Recommendation Report for Planning Permission for Works or Extension to a Dwelling

REF NO: FP/267/21/HH

LOCATION: 23 Links Avenue
Felpham
PO22 7BL

PROPOSAL: Single storey flat roof rear extension with associated lantern. Single storey flat roof side porch and erection of a detached garage including demolition of existing garage.

Site	23 Links Avenue, Felpham, Bognor Regis PO22 7BL	Date	05.01.2022
		Sheet	21-1944 D06 Rev 0
		Job	New Extension & New Garage
		Scale	As Shown@A1
		Title	As Shown

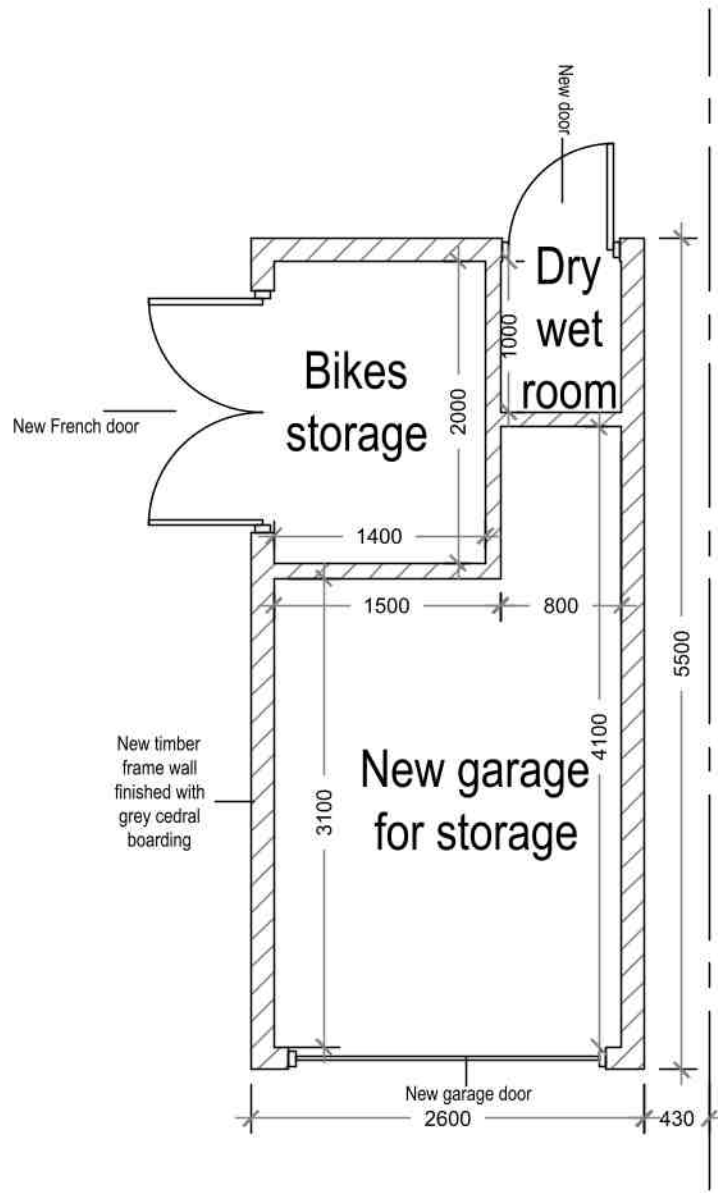
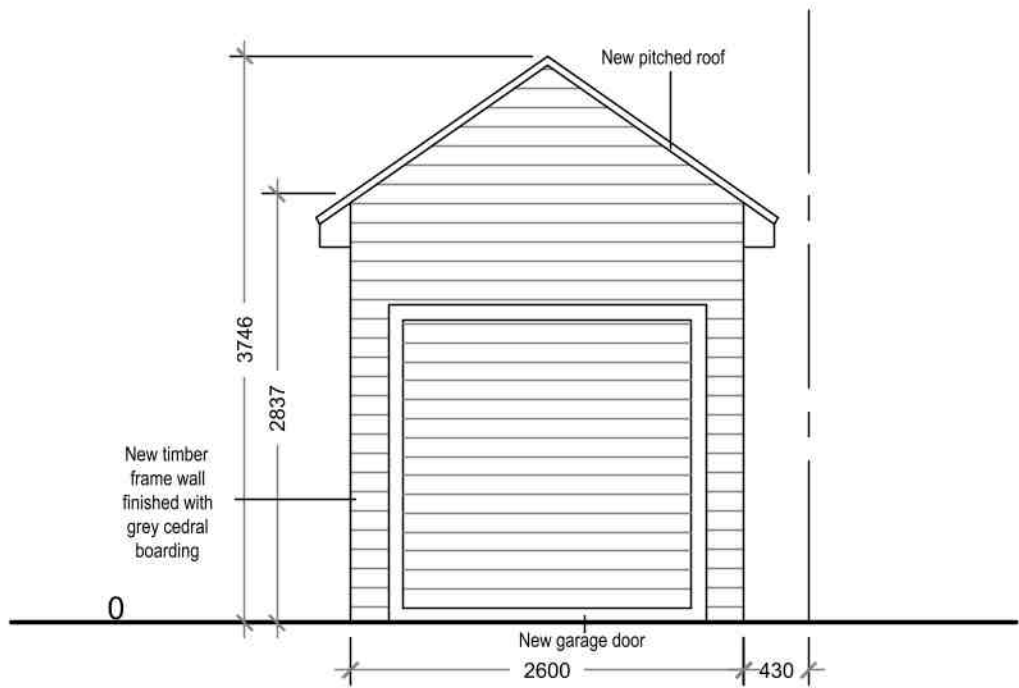
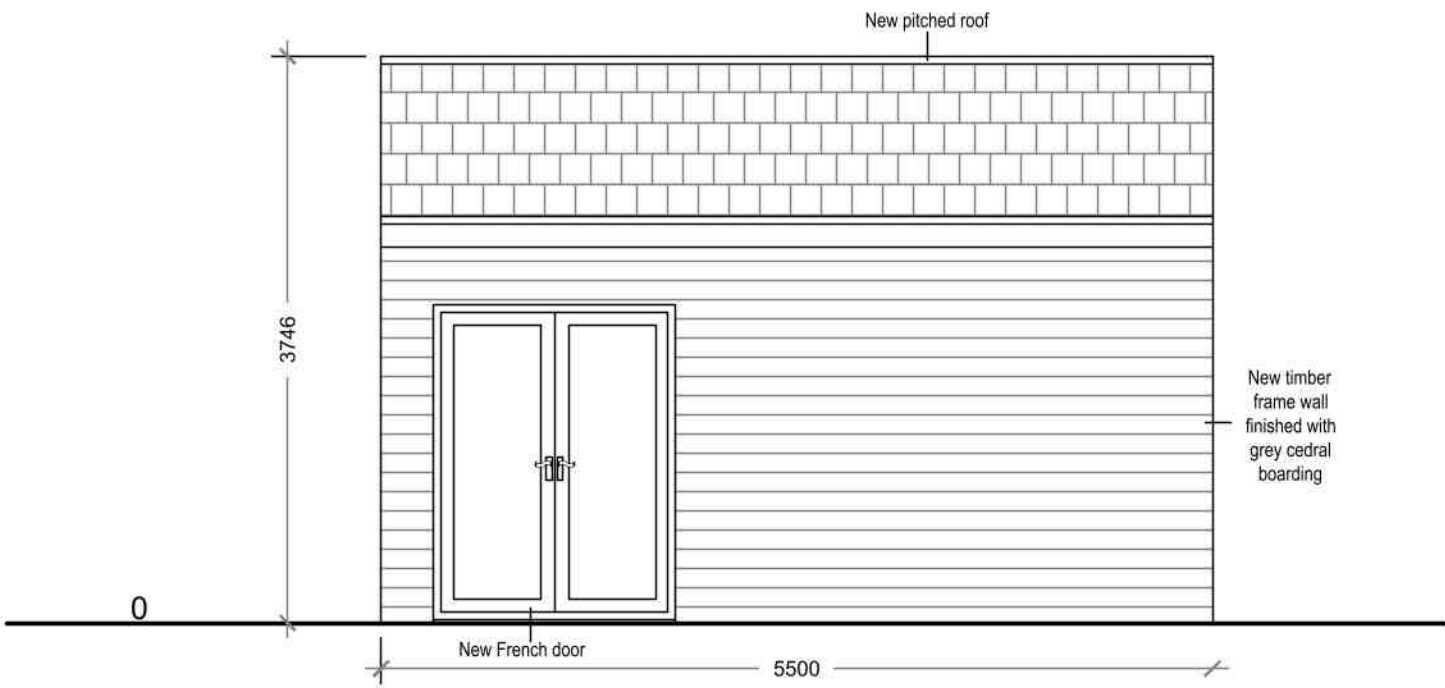
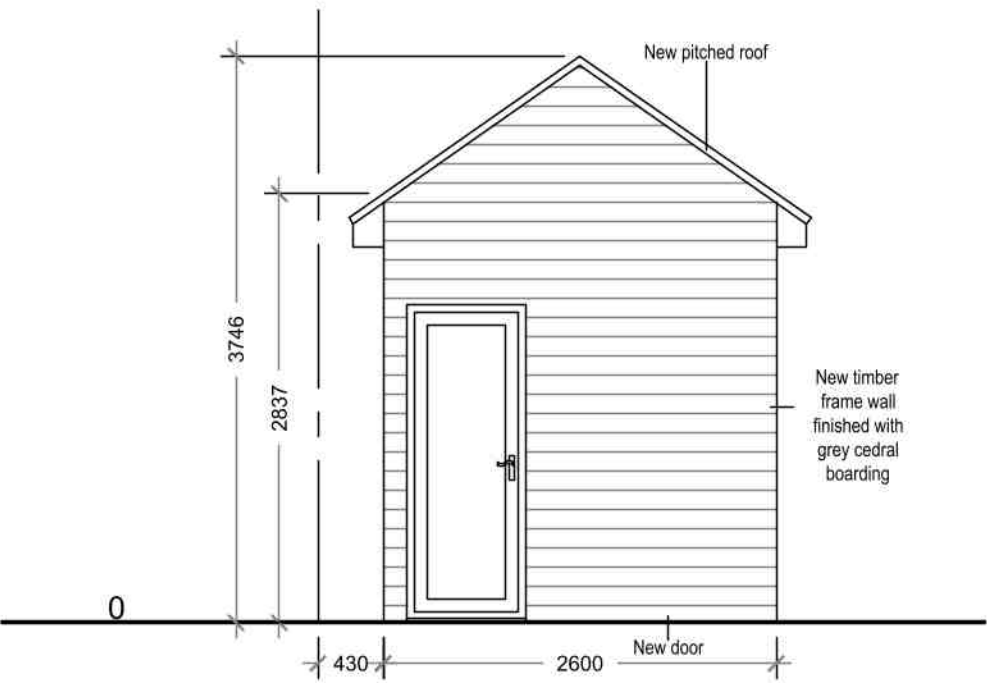
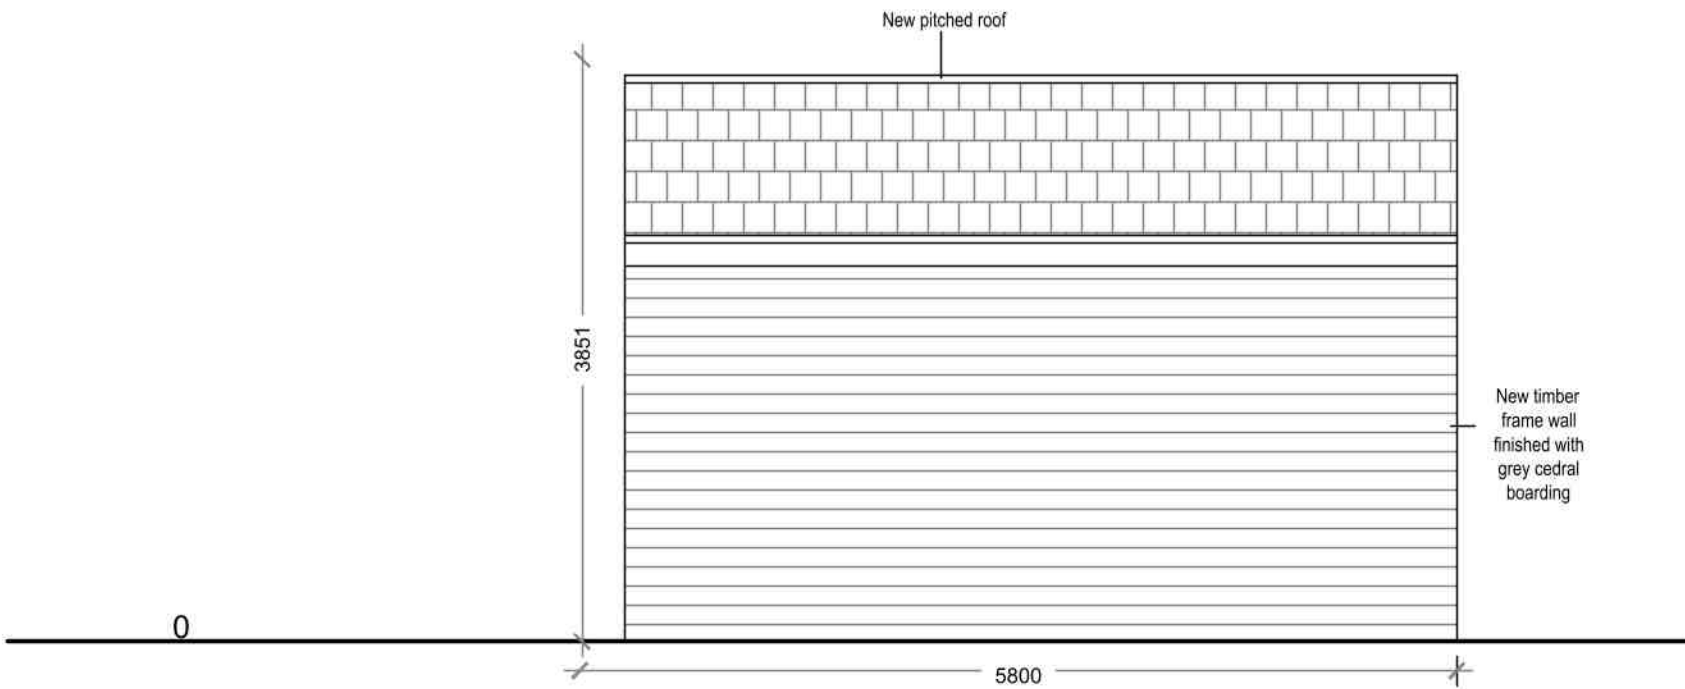
The garage does not extend further forward than the garages existing location although moves to the opposite site on the property. The roof design will alter from a flat roof to a pitched and will increase in height. The garage sits to the front of the dwelling and retains 5.8m to the front boundary.

The Arun Design Guide states 'Front extensions must take care not to disrupt the existing composition of the street in terms of rhythm or building line'. Extensions should respond to and complement the existing character and appearance of the building. The garage is considered to comply with this. It will have a gable roof which is in keeping with the design of the surrounding properties.

The garage will have a height of 3.7m with eaves to 2.8m. This is high although due to it siting and with the roof sloping away from the boundary will not result in adverse harm upon No. 25. Around 3.2m is retained from the boundary to the side elevation of No.25 and the siting of the garage does not intersect a 45 degree angle when drawn from the closest ground floor window to the boundary from this property.
